From: Rhiannon Lloyd
Sent: 17 December 2024 11:16
To: REDACTED
Subject: AL/130/24/CLP - Little Lamorna

I am the case officer for this application.

Mr. A Hammett  
Little Lamorna, Lidsey Road, Bognor Regis,  
West Sussex, PO20 3SU  
PROPOSED ELEVATIONS  
A3 PAPER  
Date Nov 2024 Scale 1:50

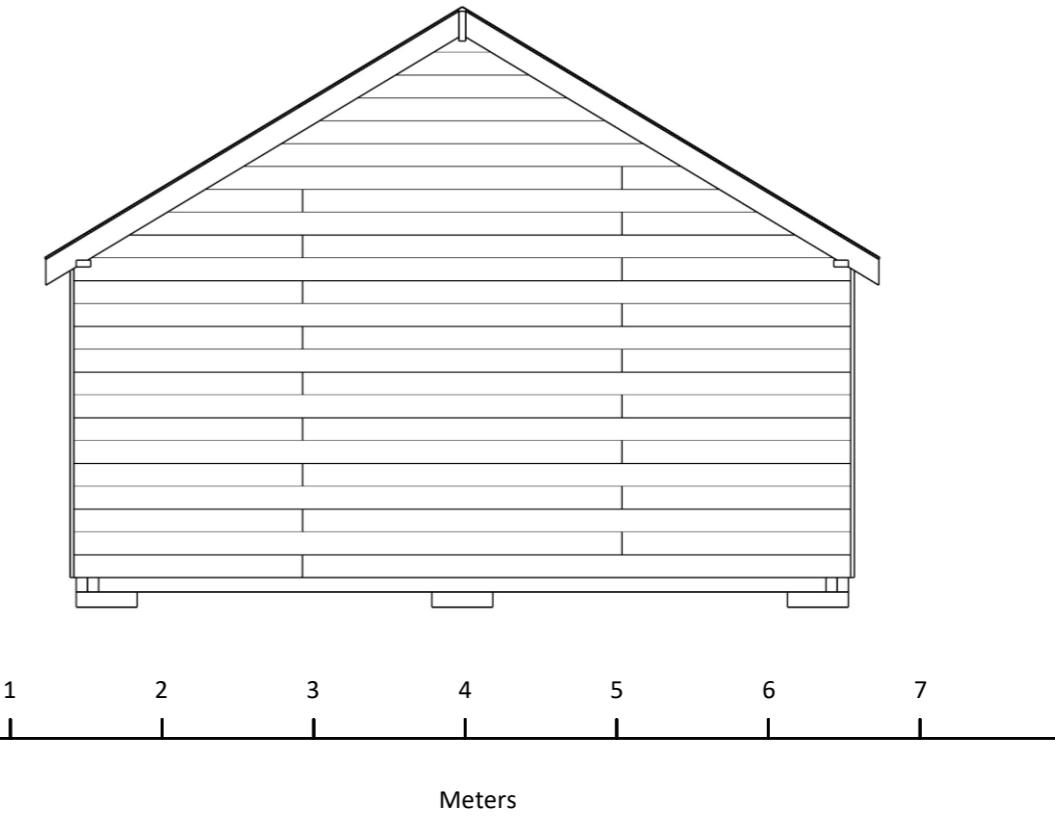
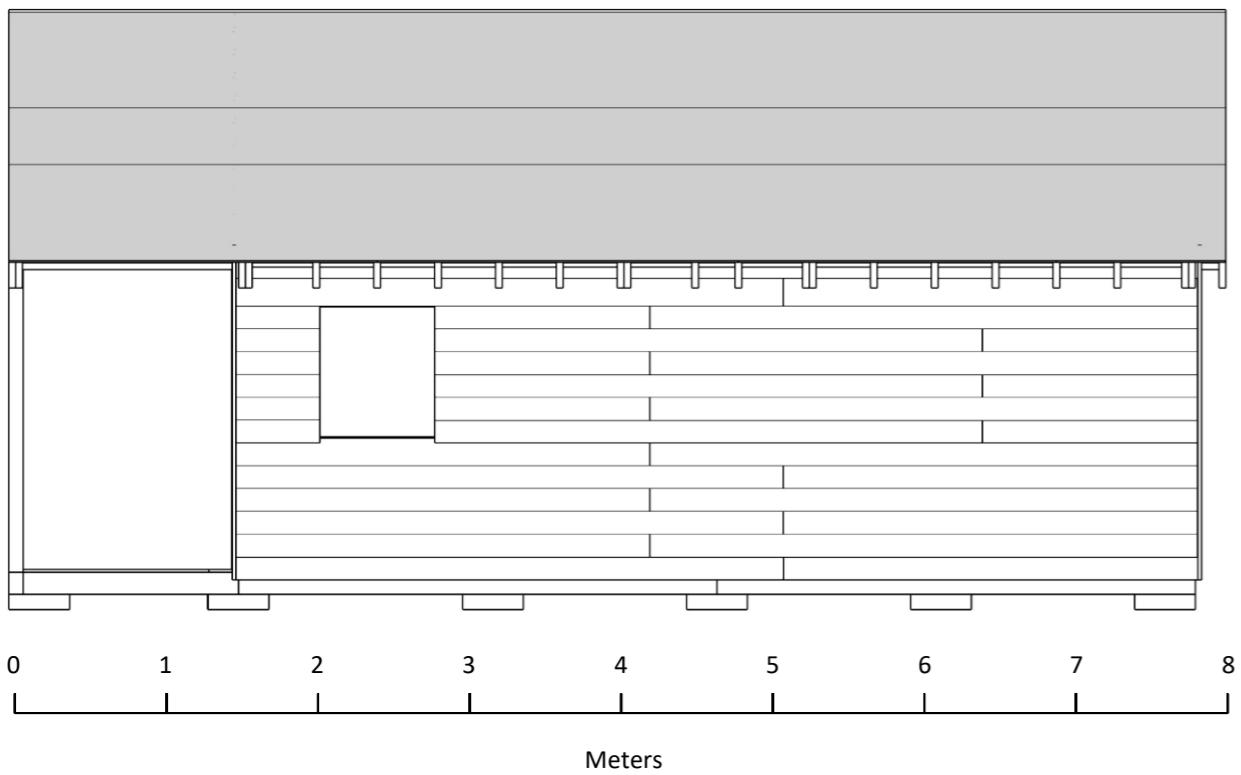
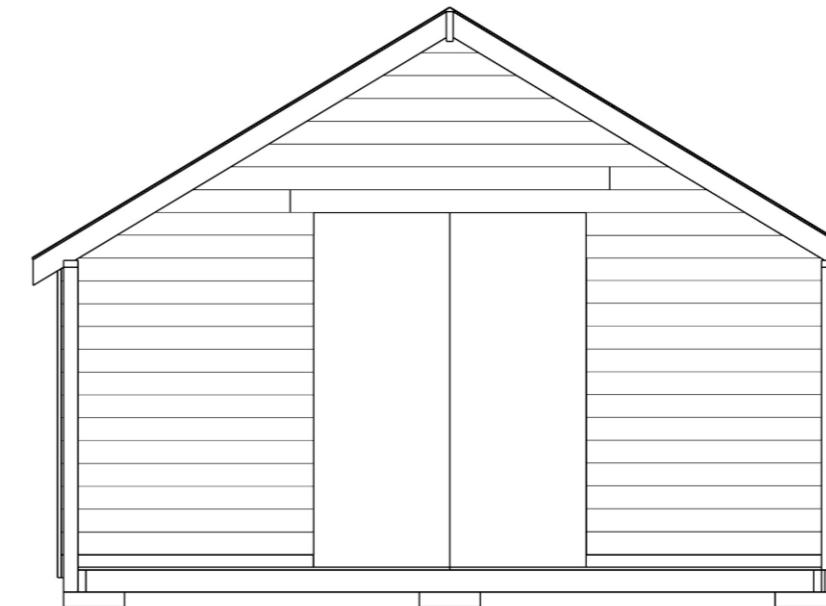
I note the proposed development includes a verandah. This would not be acceptable as below.

As per the General Permitted Development Order 2015, Schedule 2, Part 1, Class E, Section E.1:

Development is not permitted if “it would include the construction or provision of a verandah, balcony or raised platform.”

Therefore, please amend the plans if you wish to continue as a Certificate of Lawfulness.
